Application by Rosefield Energyfarm Limited for an order granting development consent for the Rosefield

Solar Farm (EN010158)

Comment on responses to Examining Authority's second written questions (biodiversity)

Claydons Solar Action Group (CSAG)

Figure 1: Other NSIPs and Major Developments considered for Inter-Project Cumulative Effects

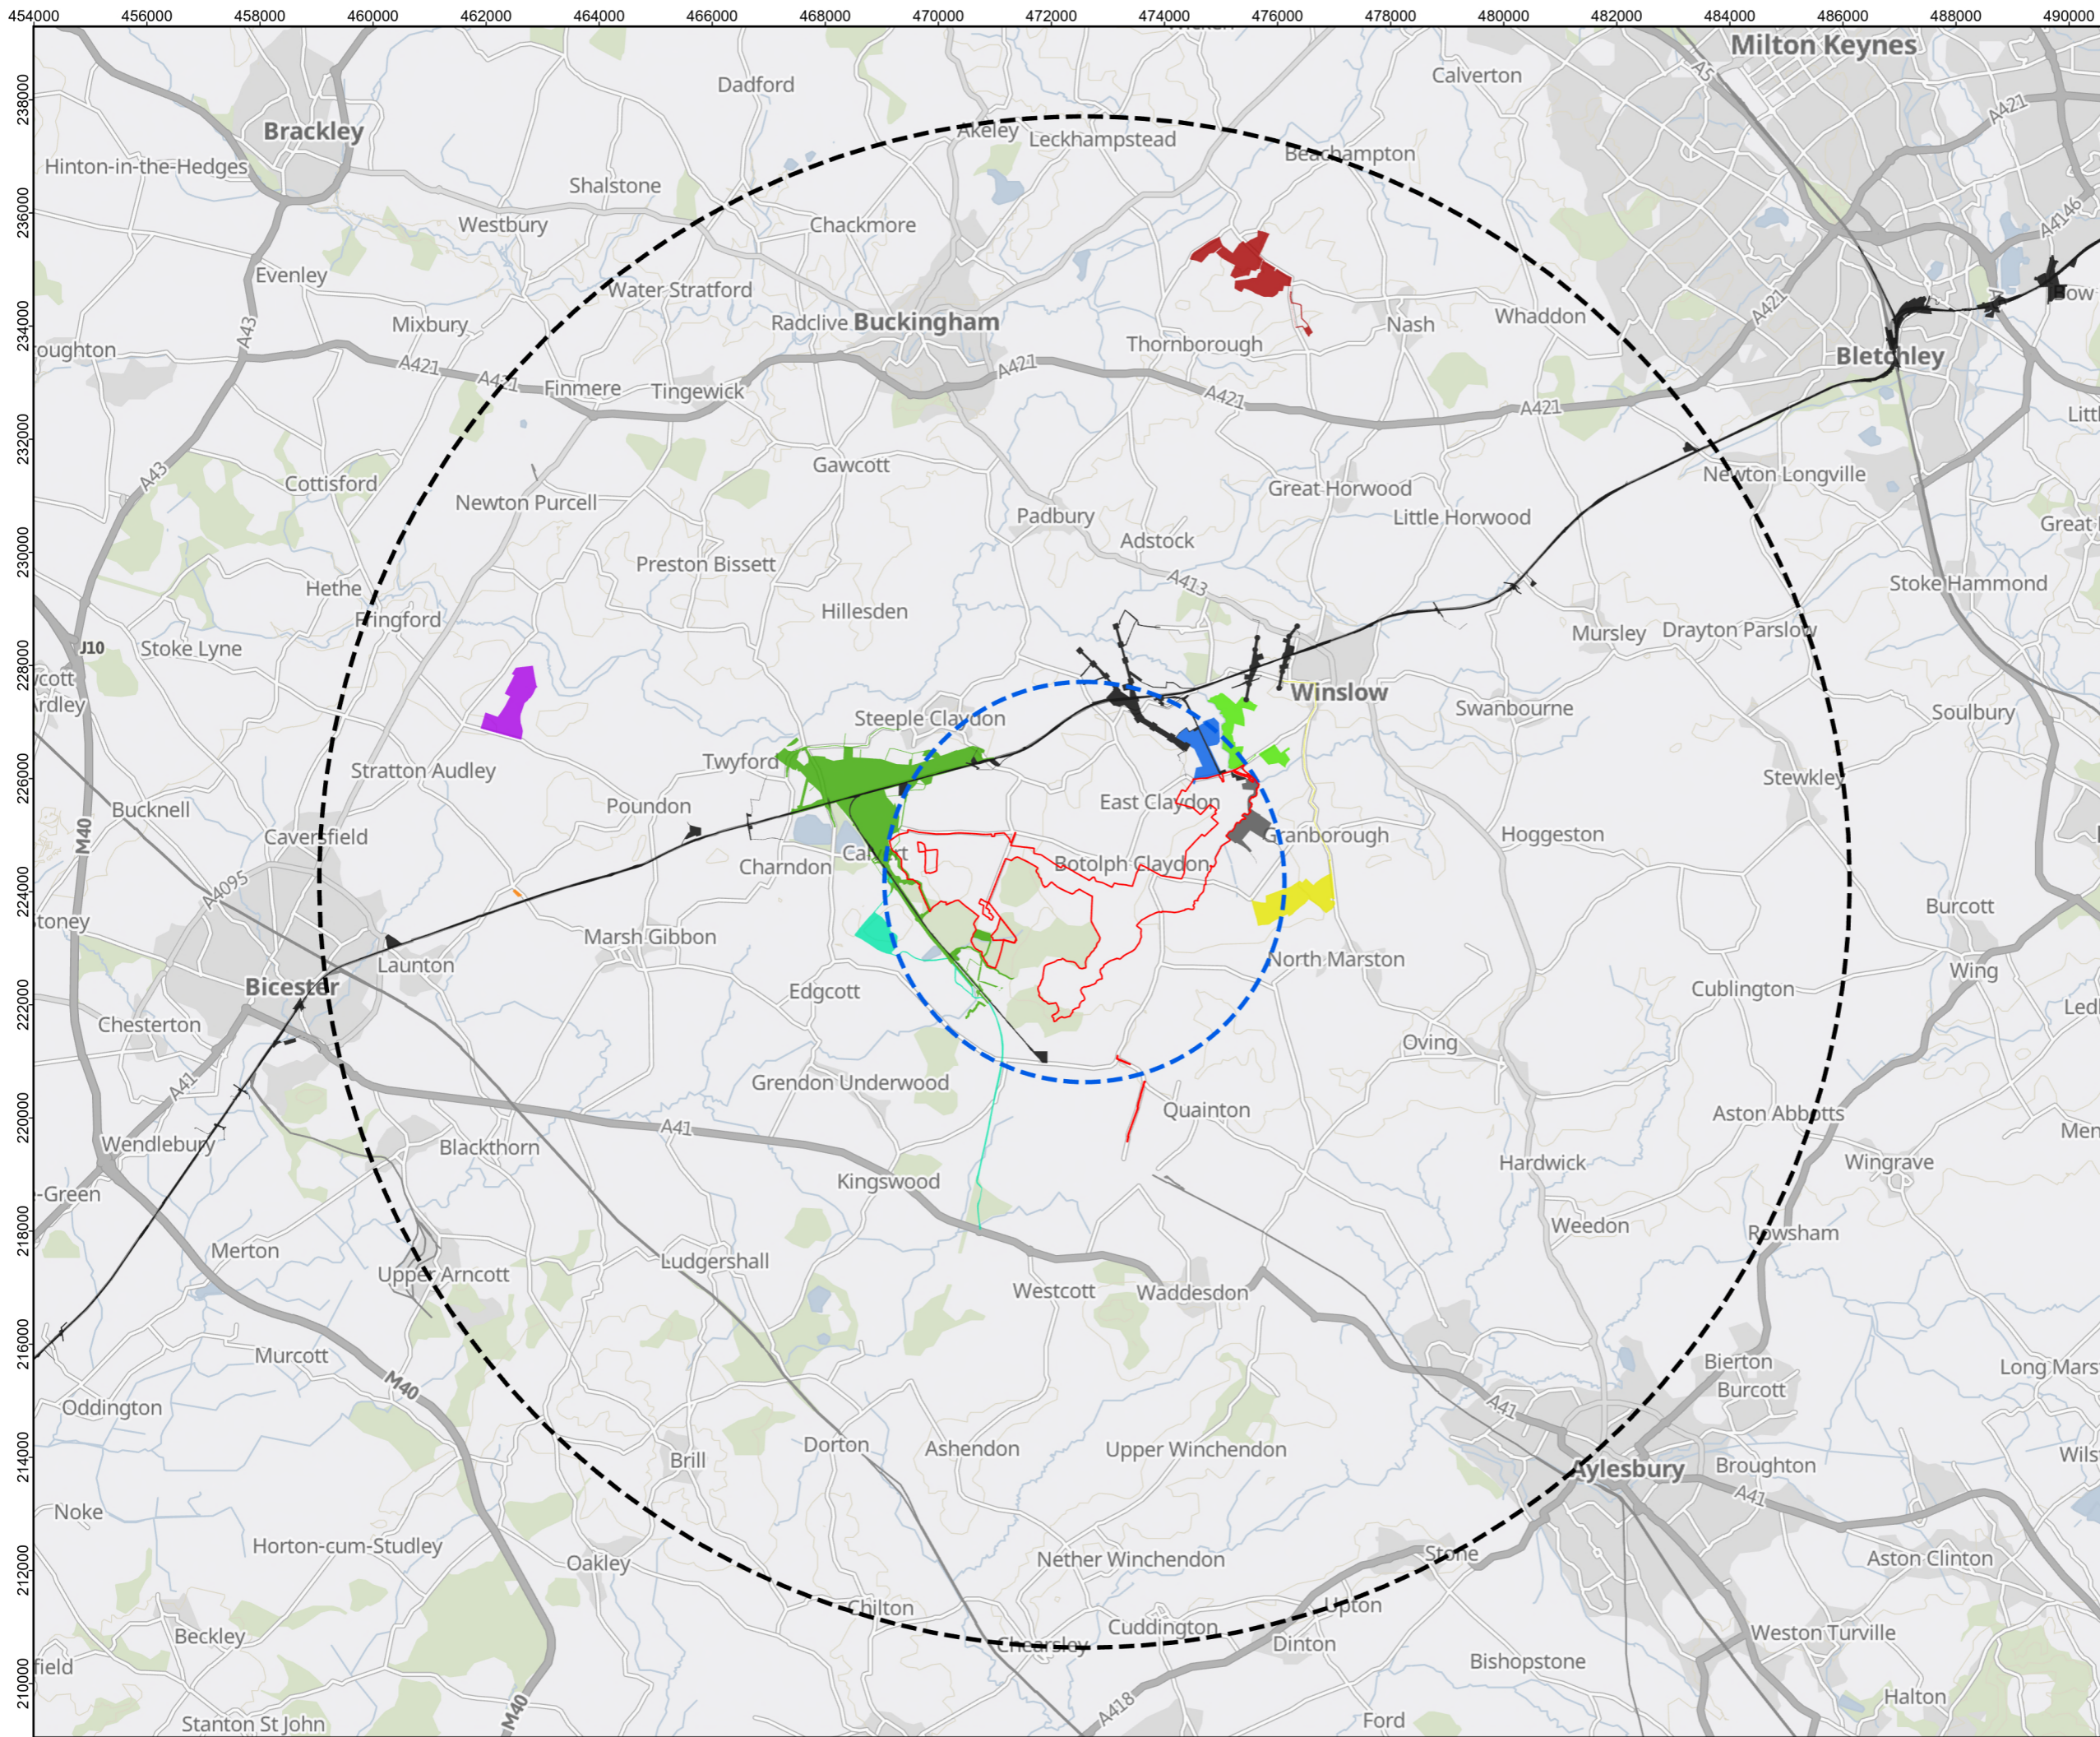
Figure 2 (REP6-068) shows the construction phases of the Statera and Stakraft projects with a gap of 6 months between them. Given that the actual connection dates for either scheme are not known and that they are dependent on the new East Claydon National Grid substation, a reasonable worst-case scenario would assume a significant overlap in the construction period of these schemes. Construction may also coincide with the redevelopment of the substation, which is not included in the table and, of course, with the Rosefield scheme itself. The Applicant has potentially significantly understated the cumulative impacts of construction of the series of large developments planned in the immediate vicinity of the Order Limits.
--	--	---

TITLE:
 FIGURE 3.9D
 INDICATIVE CONSTRUCTION AND OPERATIONAL
 ACCESS - PARCEL 3

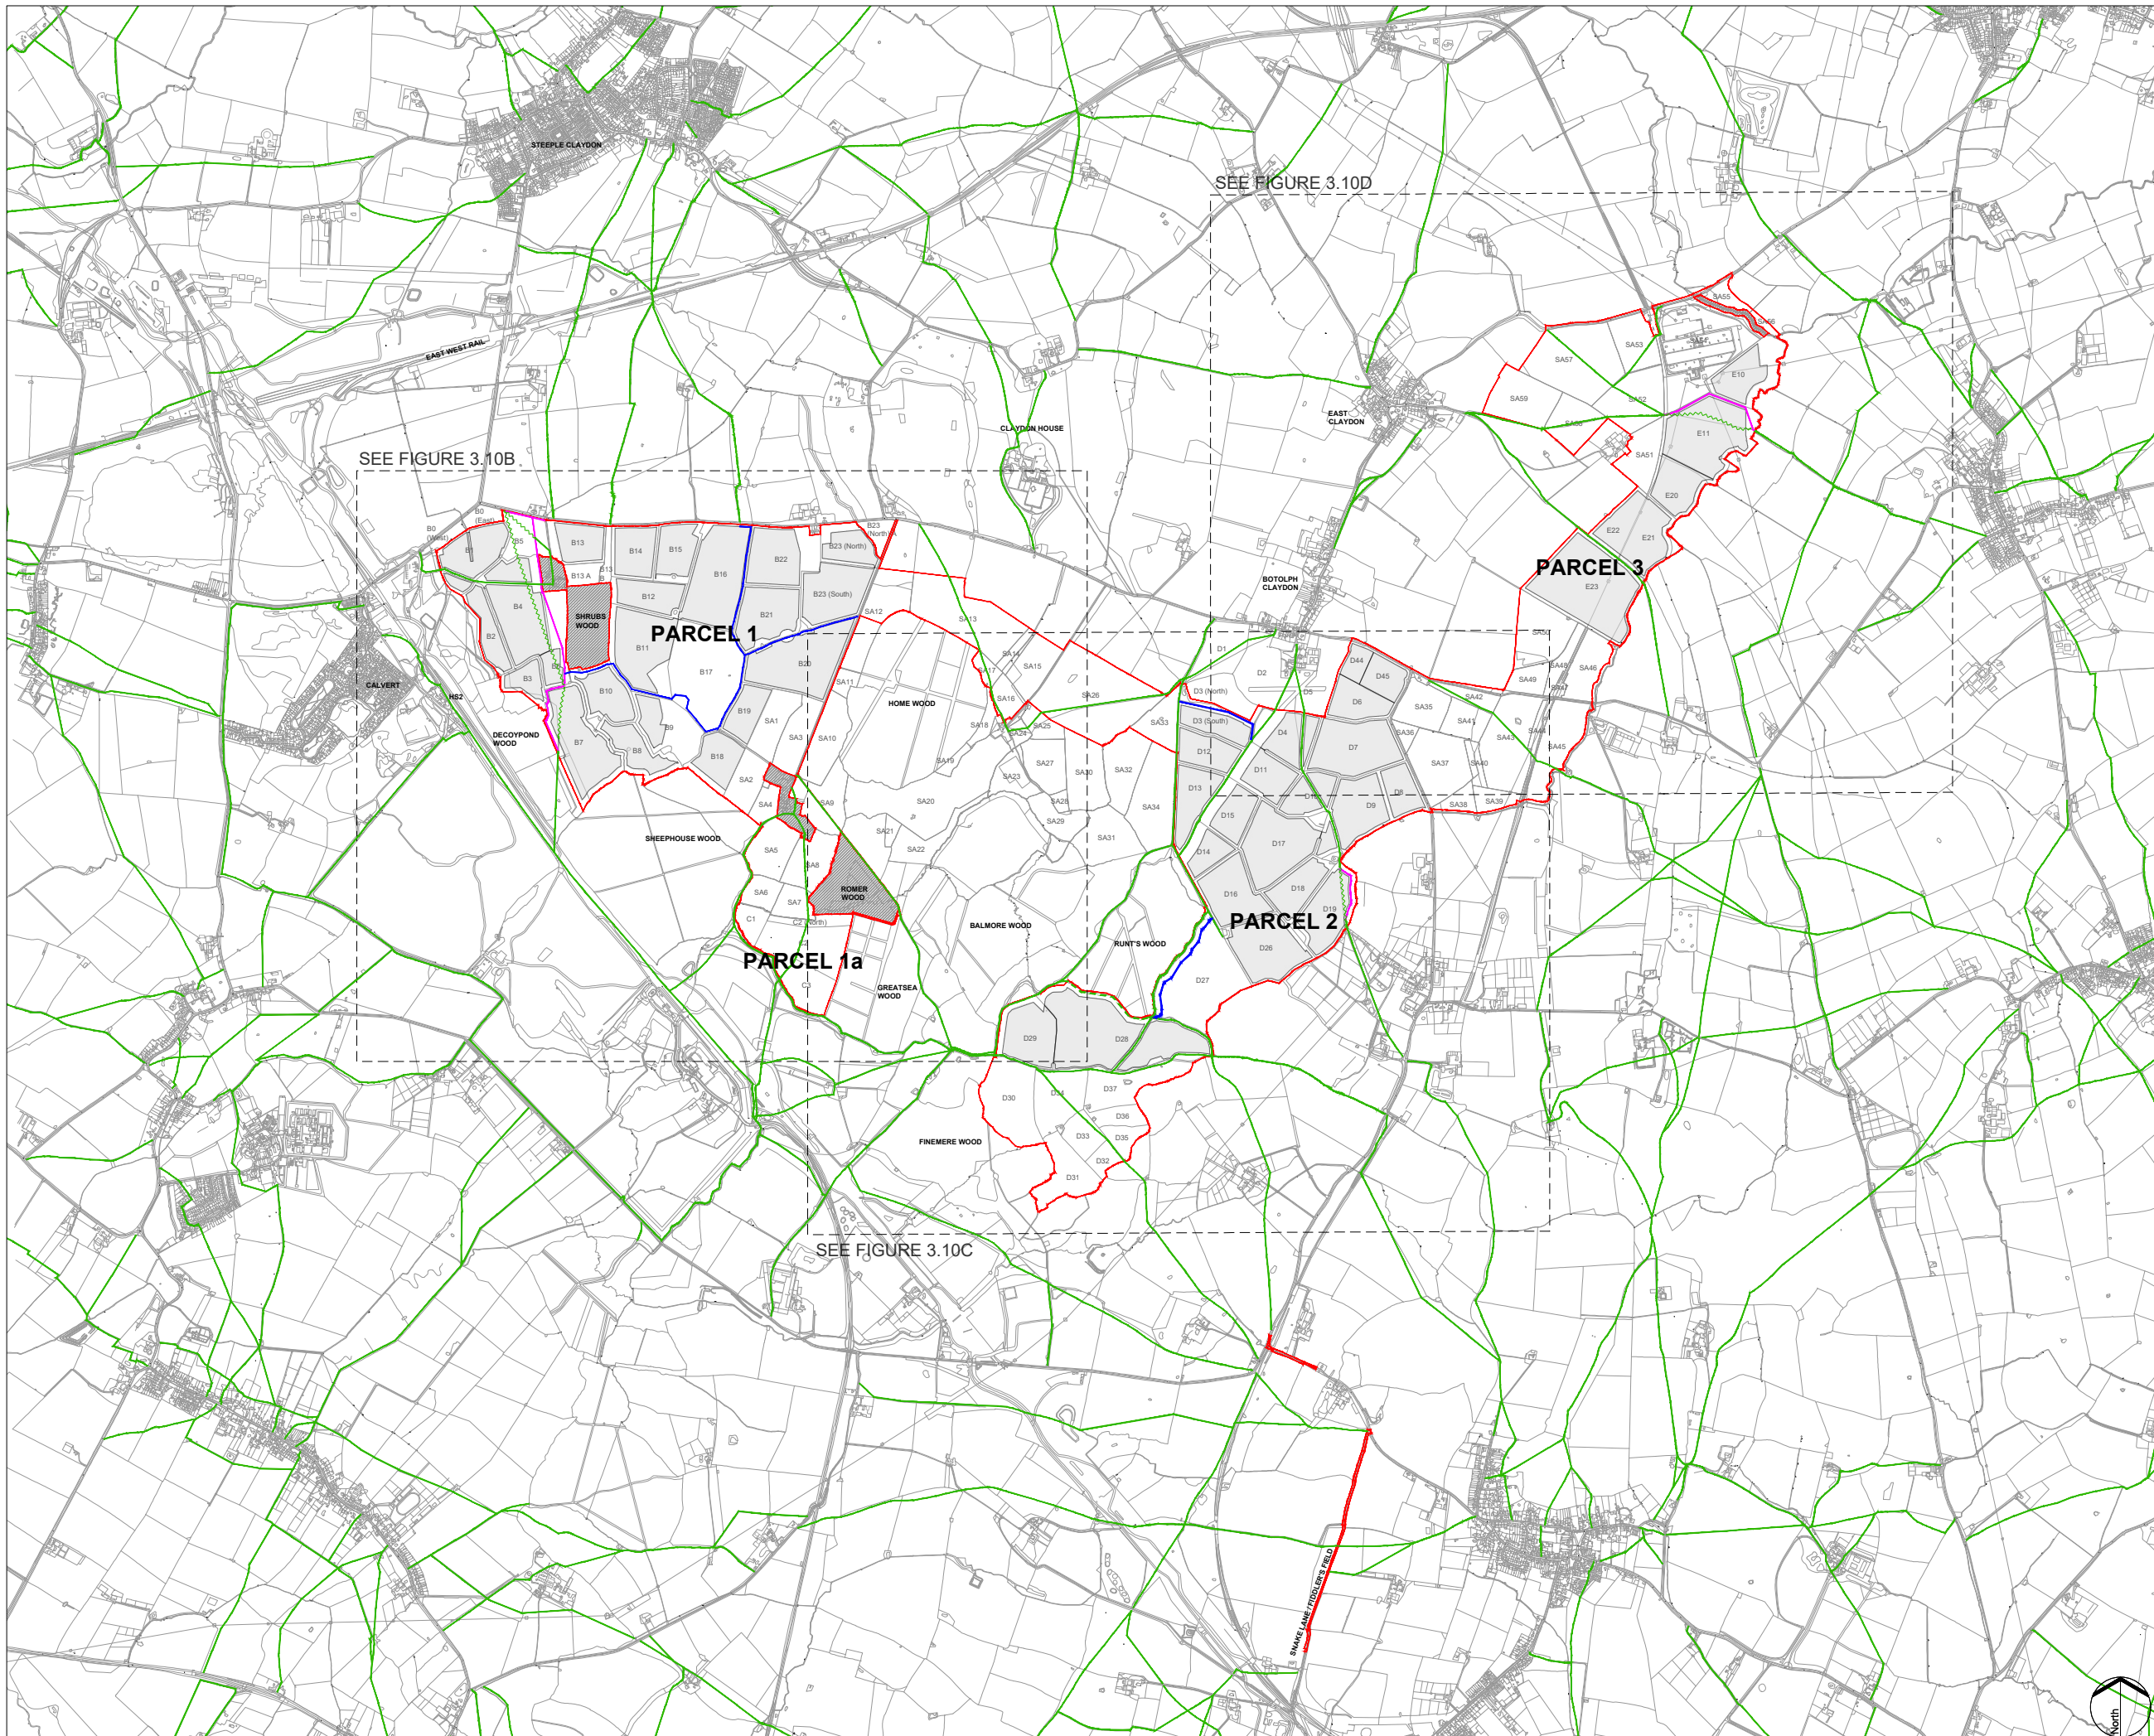
One matter to which CSAG wishes to draw the ExA's attention is the last-minute change to the proposed access on the East Claydon Road, which had been said throughout the Examination to be a temporary access for some AILs only. Without any explanation or assessment, this is now intended as a permanent access throughout the operational (and presumably decommissioning) periods. See page 15 below.

<i>biosecurity measures would be implemented along the southern route when it is in use.”</i>	would be limited to AILs and so, effectively, this would be a temporary measure during the construction period. However, at the eleventh hour, the Applicant has stated that, during the operational phase, the access points for cars and LGVs would include that from East Claydon Road. The changes in the Deadline 6 ES update raise a number of important issues. The Applicant proposes creating their own site access from East Claydon Road, seeking a 50 metre flexibility option in its location (Draft DCO – see below) and requiring 51.5m of hedgerow to be removed. It is not clear how this relates to the temporary entrance to be used by Statera or whether Statera would plan to use the entrance
--	--	---

on a permanent basis (contrary to the terms of the planning permission). What would be planned in terms of materials used for the access track and how would the Claydon Brook be traversed given that the Statera plans were for temporary structures? It should be noted that no baseline surveys have been undertaken by either party. It bears reiteration that Fields SA55 & SA56 are subject to severe flooding at times and it is not clear how this will be managed. Para. 2.17.3 of REP1-078 (ES land and groundwater chapter - construction phase) states, <i>“The Abnormal Indivisible Loads (AIL) access located in the north of Parcel 3 would not be used during flood events.”</i> Para. 2.4.5 of REP1-080 (EIA Scoping Opinion) states, <i>“During the operational (including maintenance) phase, the Abnormal Indivisible</i>
--	--	--

<i>Loads (AIL) access located in the north of Parcel 3, would only be used should unforeseen events occur which result in the Rosefield Substation requiring replacement. The AIL access would not be used during flood events."</i> Do these provisions apply to other vehicles? What is to prevent non-AIL vehicles using this access point during all phases of the project, and what are the implications of the proposed changes to the Transport Assessment and cumulative impacts with other infrastructure projects? Corresponding changes proposed for the Draft DCO are as follows: <i>Limits of deviation (Part 6: 50).</i> <i>(1) Subject to paragraph (2), in constructing the permanent means of access at AS-A1 between</i>
--	--	--
